APPLICATION NUMBER: 06_0259
**LOW PRESSURE WATER PUMPING STATION, BAYSWATER POWER STATION,
HUNTER RIVER, SINGLETON LOCAL GOVERNMENT AREA**

Response to Public Display Submissions

Flow Duration Curve - Downstream of Macquarie Generation Pump Site

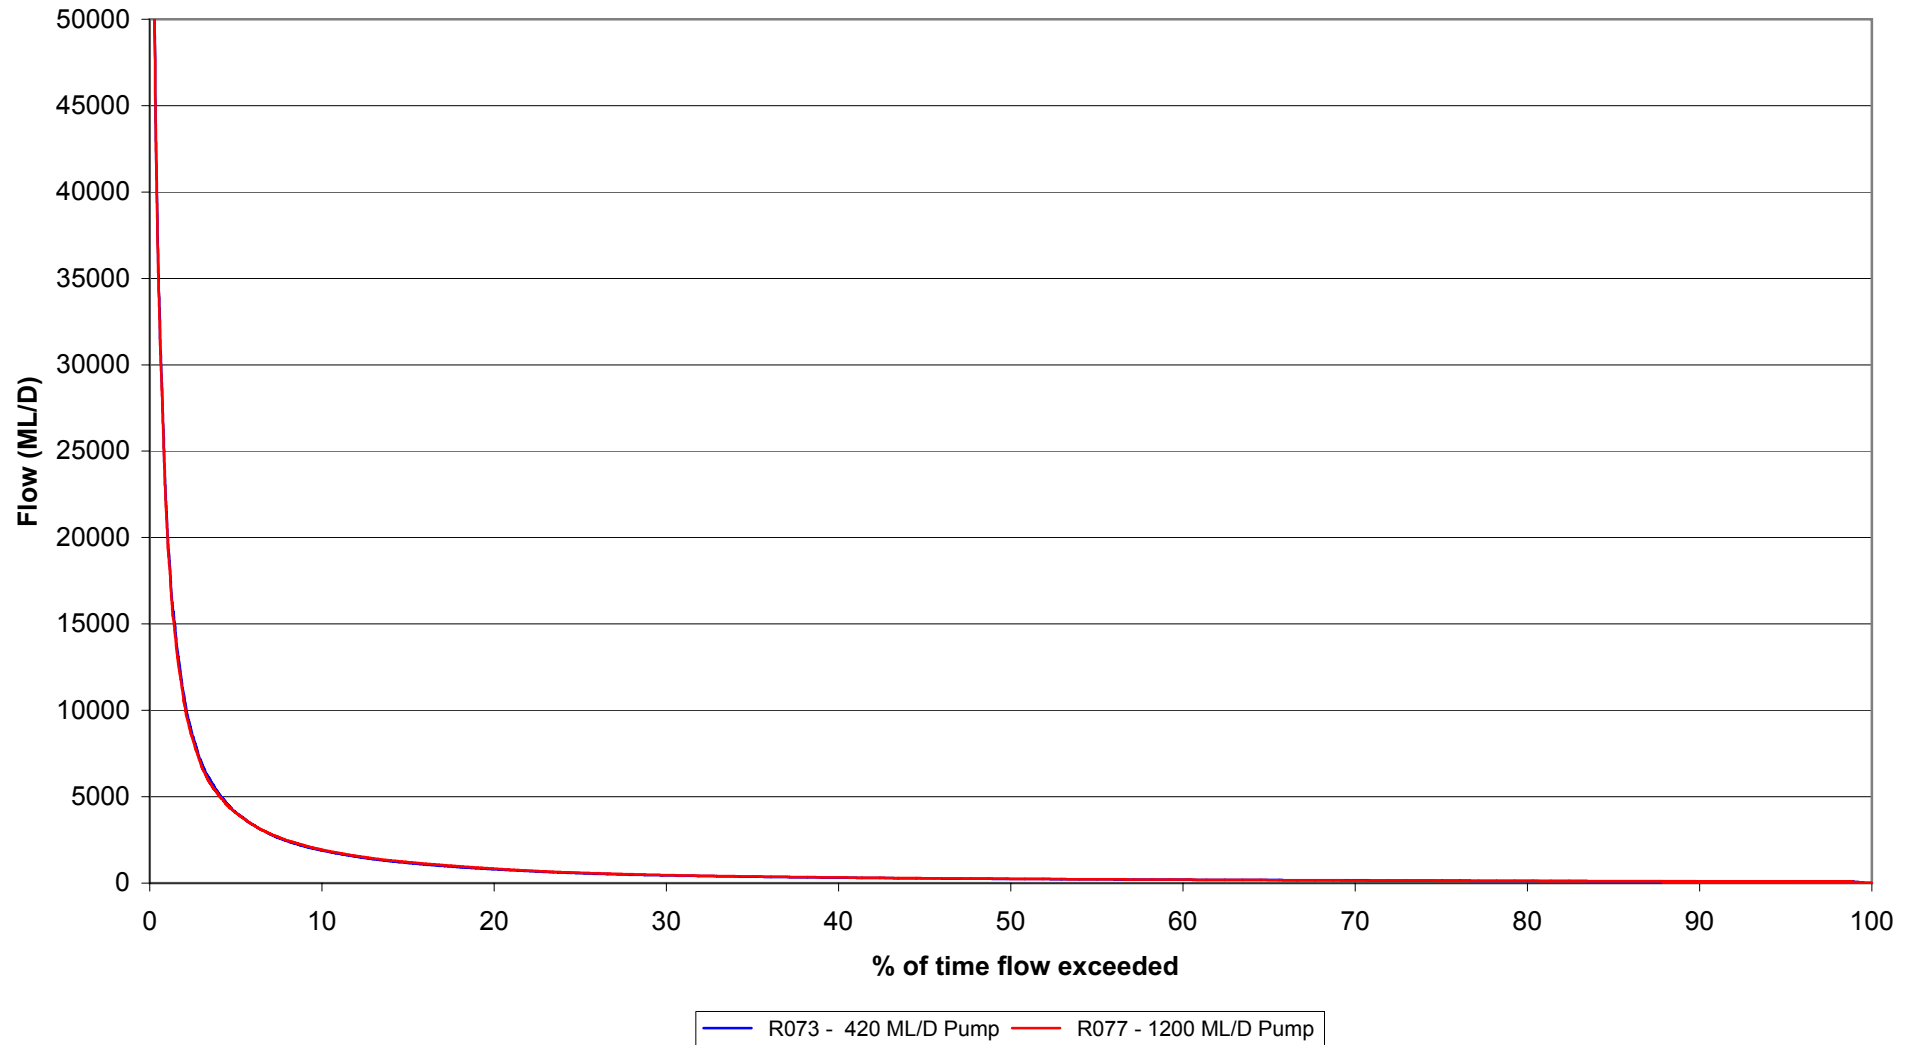
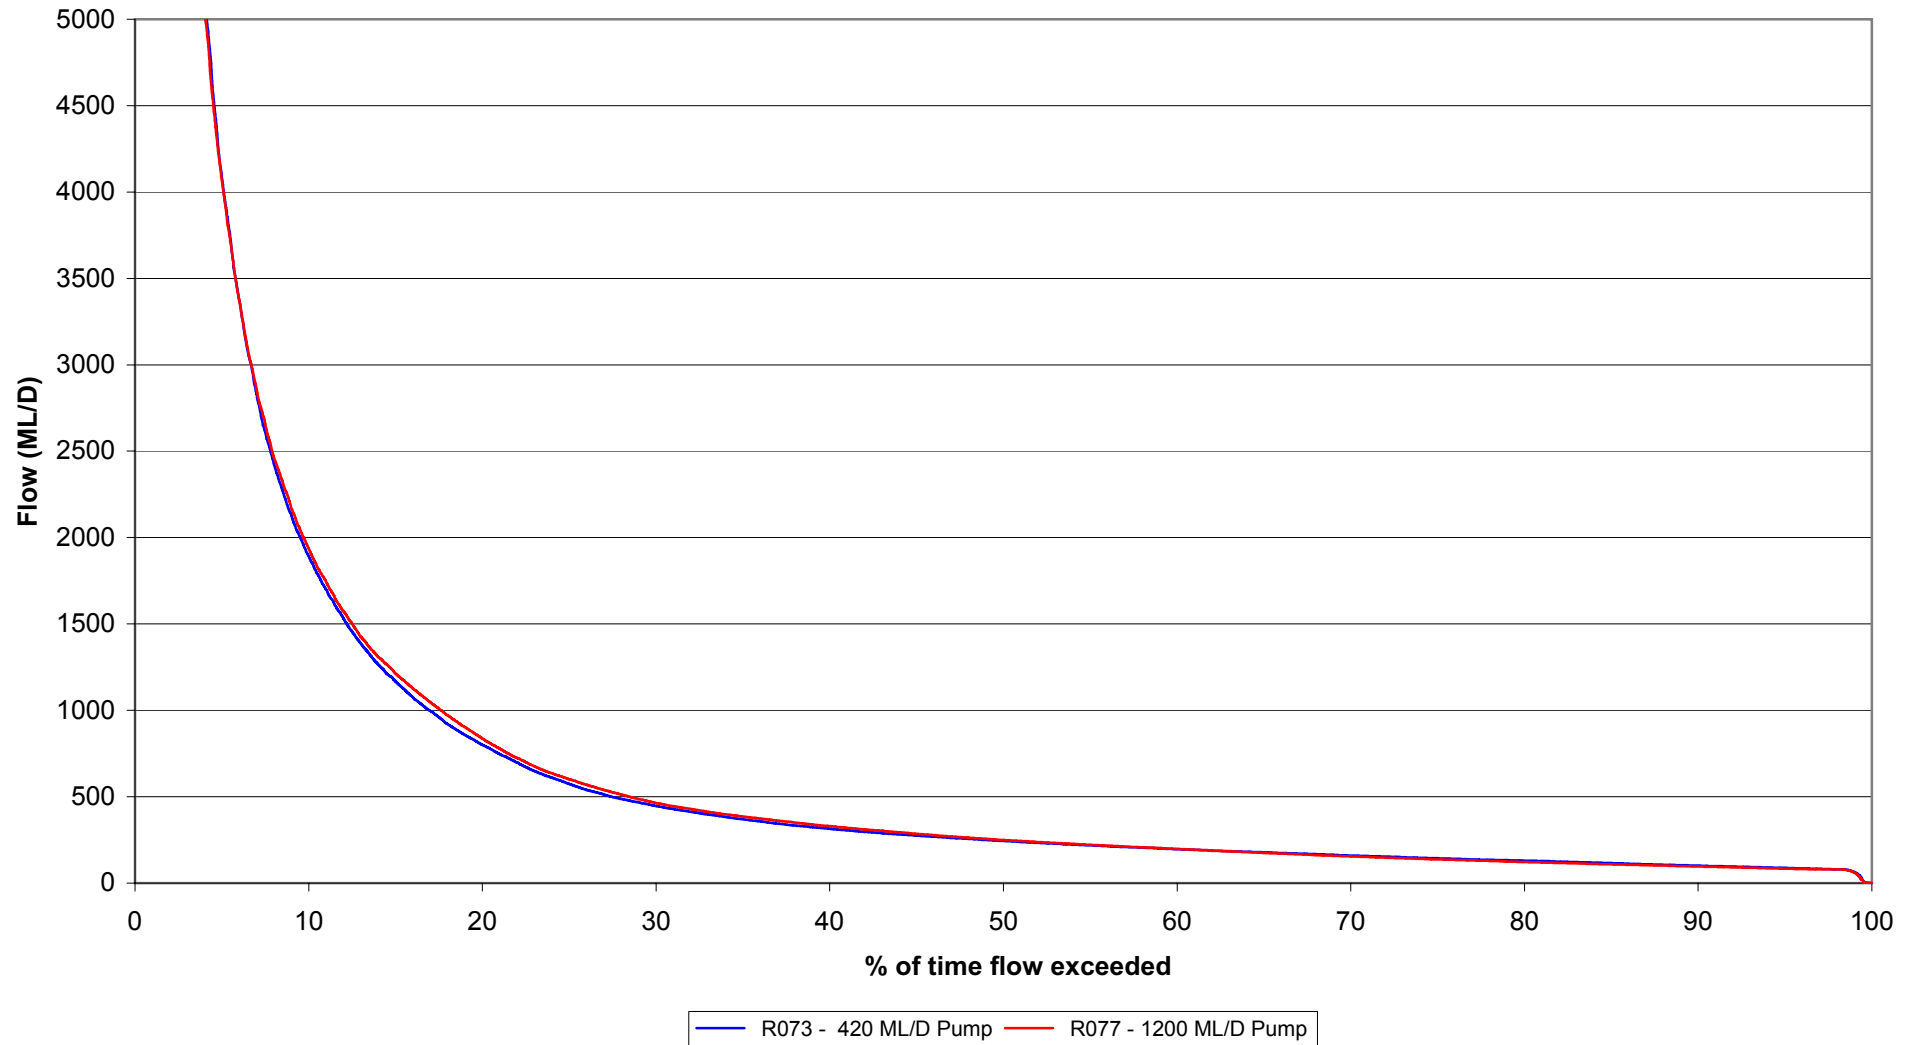
Issue	Response
<p>Issue 1.1) <i>“Hydrological Assessment Figure 5.1 Flow Duration Curve in the environmental assessment (EA) should be replotted with a Y axis from 0-3000 ML/day to show the impact of higher flow rate at relatively low flow rates. Most of the impact will be below 2000-3000 ML/day. The EA should address this issue to permit further discussion”</i></p>	<p>Response: Agreed, Macquarie Generation will modify the graph in the EA, and will forward a copy to the Department as soon as it is completed.</p>
<p>Issue 1.2) <i>“The EA states that the operation of the new pumps will be automated based on the flow condition at Jerrys Plains in accordance with the condition of the licence. Details of such automatic operation should be illustrated in the EA using sample flows and pumping rates including step up and step down rates”</i></p>	<p>Response: Agreed, Macquarie Generation will provide details as soon as the design is finalised. The design of the automated operation of the pumps has not been finalised as variable speed control is currently being assessed. If variable speed control is implemented, pumping will be able to follow the river hydrograph precisely, without any step-up or step-down required.</p>
